DISAPPROVED  
Plan Review

EPC Planning & Community  
Development Department

R121563  
ADD19685

OWNER: MOORE, JOSHUA  
LOCATION: 7480 SHOUP RD  
ZONING: RR-5 AREA: 21.67 Acres

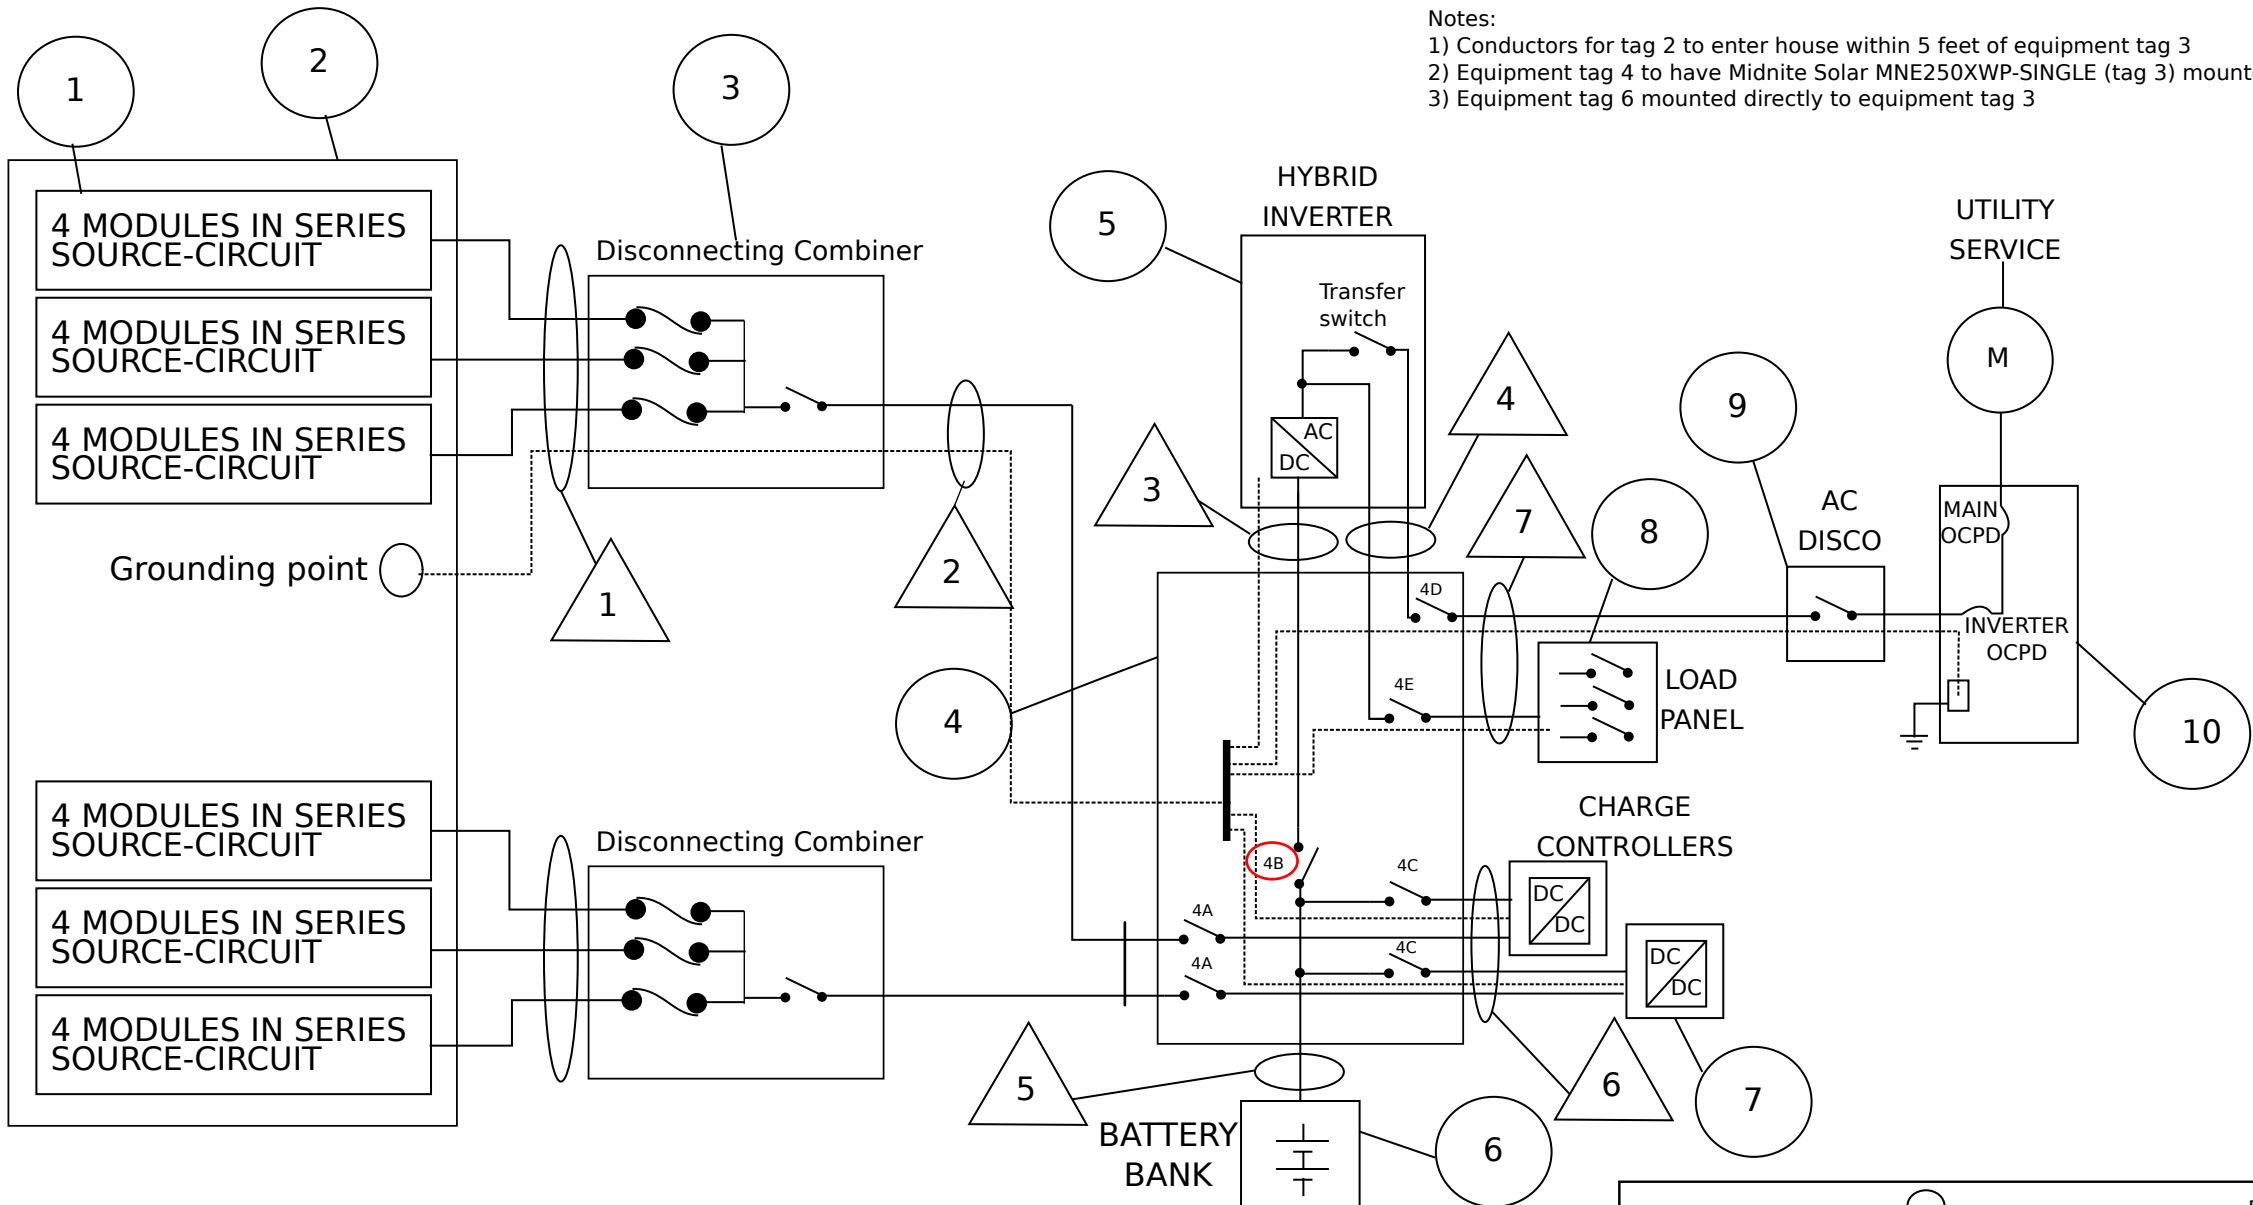
PROVIDE DIMENSIONS (WxLxH) OF  
GROUND MOUNT PV SOLAR ARRAY AND  
SETBACK MEASUREMENTS TO FRONT,  
WEST SIDE, AND REAR LOT LINES.
